DECISION DELEGATED TO HEAD OF PLANNING

Application No: H14-0969-21 **Applicant:** Mr M Coulam
Proposal: Erection of 2 detached bungalows
Location: Land At Horsepit Lane Pinchbeck Spalding
Terminal Date: 17th March 2022

CASE OFFICER ASSESSMENT

Block Plan

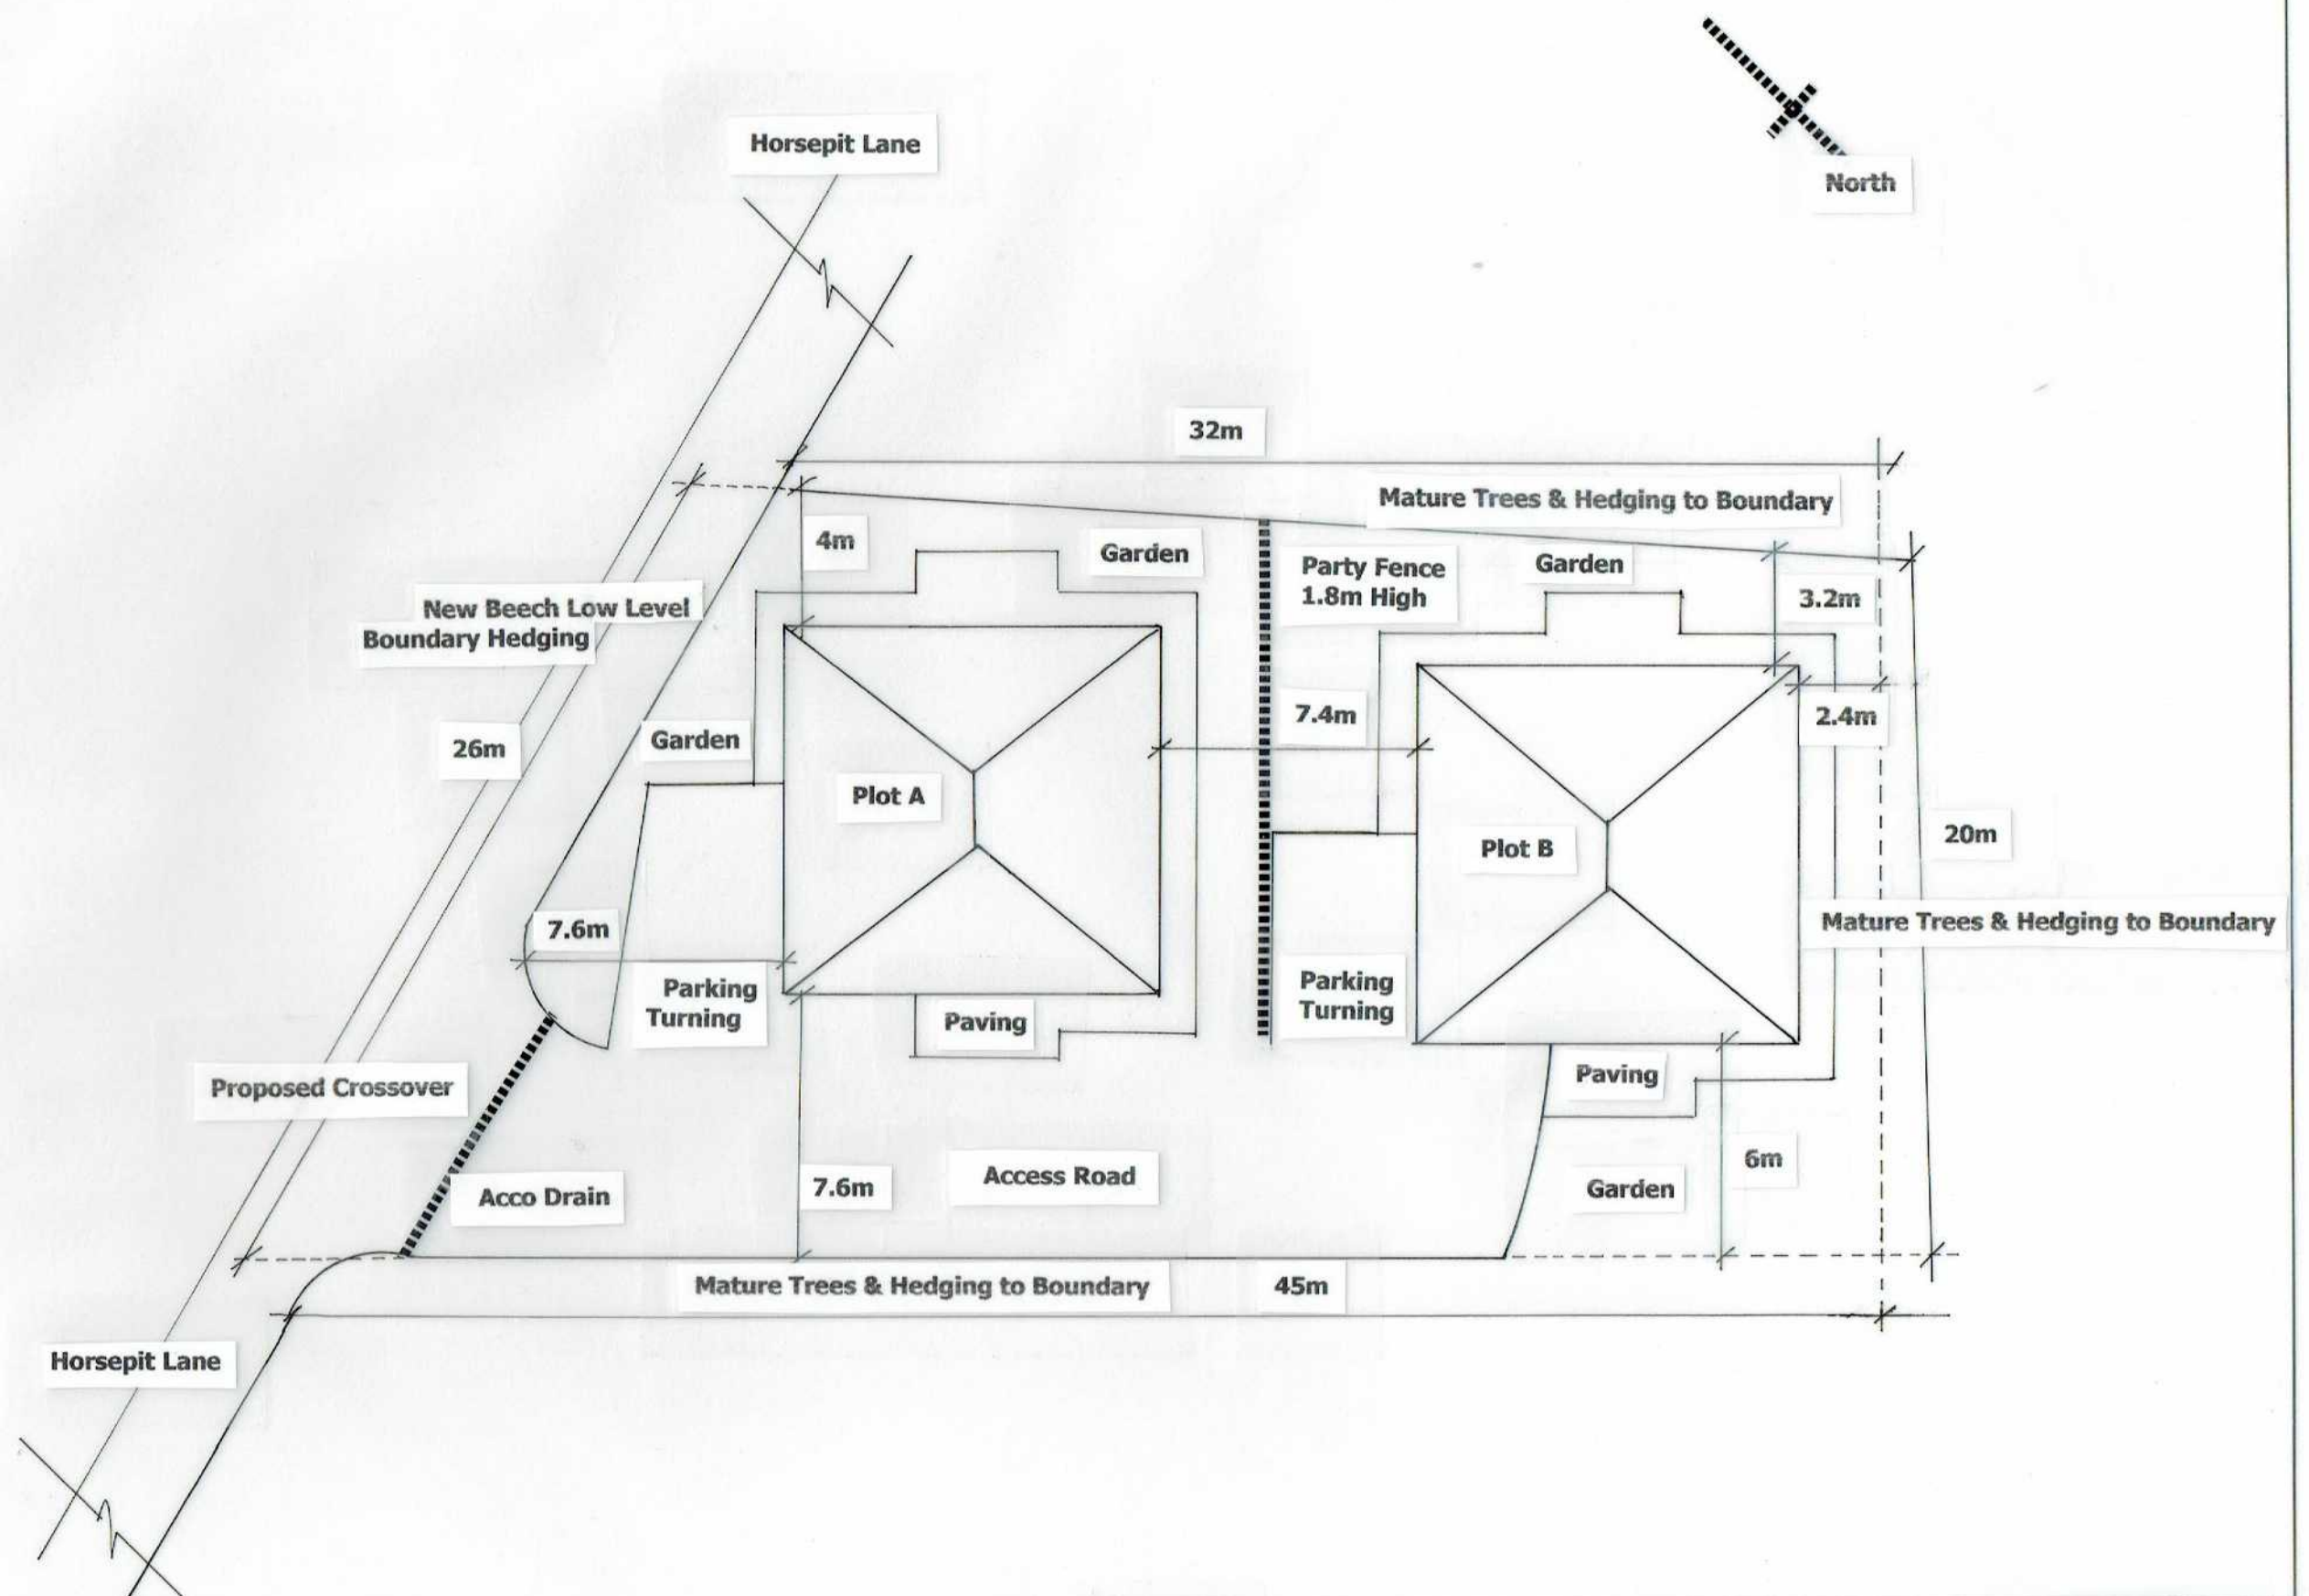
Overdevelopment - The submitted plan shows a total plot size of 887.02 square metres, when averaged between the 2 plots this is 443.51 square metres per plot. For comparison purposes 19 Horsepit Lane is 432 square metres, 21 is 566 square metres, 23 is 710 square metres, 25 is 464 square metres, 27 is 516 square metres, 29 is 757 square metres and 31 Horsepit Lane is 973 square metres. The bungalow plot sizes are therefore on the smaller side of plot sizes in the vicinity. It is considered however that by virtue of the proposed layout to facilitate the ability of vehicles to exit the site in a forward gear, there is a lack of amenity space on each plot.

Overbearing / Overshadowing - The proposed bungalow have an eaves height of 2.4 metres and a ridge height of 5.75 metres. The boundary hedge to the south is approximately 1.9 metres in height, with the separation distance to 1 Catherines Way from the rear bungalow being 9.55 metres. Given the separation distance and that the bungalow is sited to the north-north-east, there is not considered to be an overbearing impact to 1 Catherines Way. The separation distance between the two bungalows is 7.4 metres, with a 1.8 metre high close boarded fence inbetween. The frontage bungalow has an obscure glazed bathroom window facing the fence, with the rear bungalow having a lounge / dining room window facing the fence. This room is also served by a rear elevation window so there is not considered to be a material loss of light to the lounge / dining area.

Overlooking - There is not considered to be an overlooking impact to the south due to the 1.9 metre boundary hedge and fence. Catherines Way is located to the south-west beyond 1.9 metre high hedging, with agricultural land outside of defined settlement limits to the north-west and north. The lounge / dining room of the frontage bungalow is located 25 metres from 23 Horsepit Lane at the nearest point to the east. With other dwellings on Horsepit Lane located a further distance away there is not considered to be an overlooking aspect from this proposal.
